PLANNING CONSULTATION RESPONSE

Application No	2026/0503
Proposal	Erection of single storey office building (Use Class E(g)) with ancillary attached garage/store, external storage/open storage yard, formation of parking area and erection of wall/boundary treatments.
Address	Plot 9 Unit 1, Claycliffe Road, Barugh, Barnsley, S75 1HS
Date of Consultation Reply	15/07/2026
Consultee	Claire Wilson, Planning Ecologist

SITE PLAN
SCALE 1:200

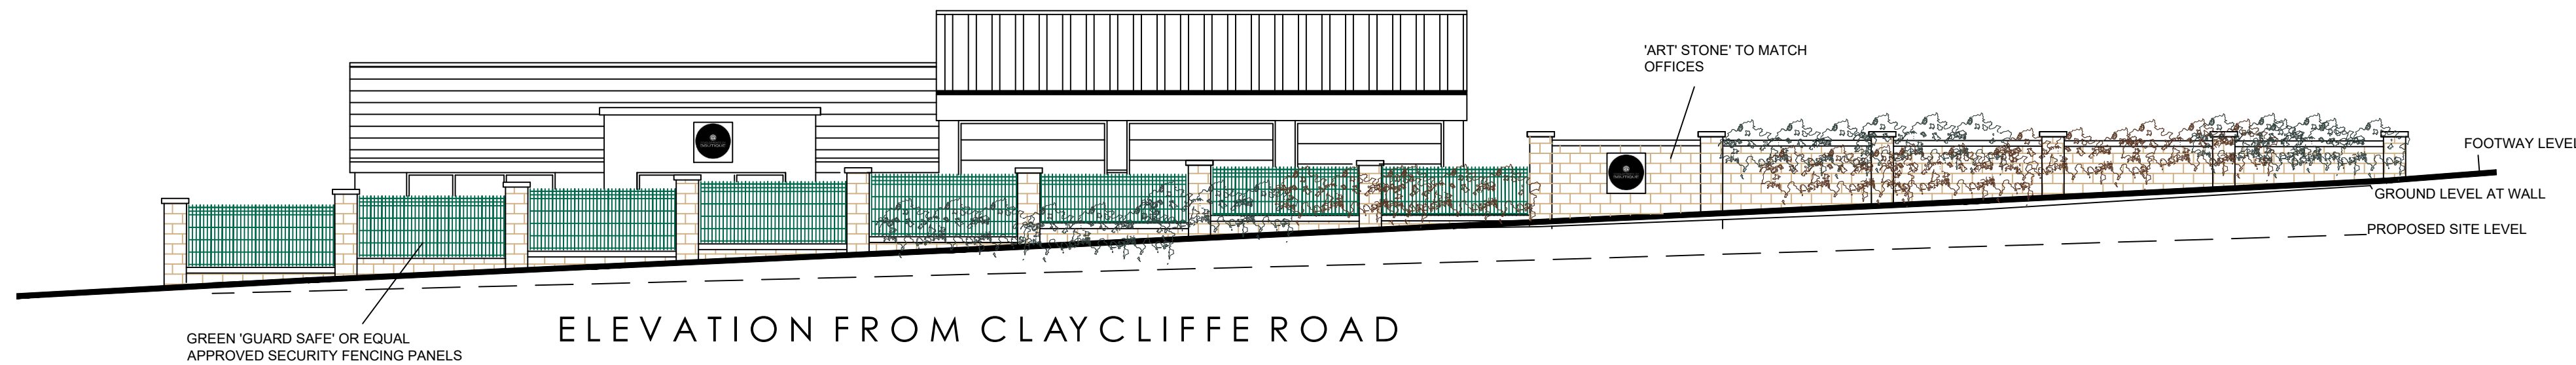
To maximise the biodiversity value of the site the planting of native trees and shrubs should be considered, where appropriate. Alongside the installation of bat and bird boxes on the new building, as per the biodiversity and geodiversity SPD. The plans and elevations drawing appears to include an area of grassland and tree planting which is welcomed.
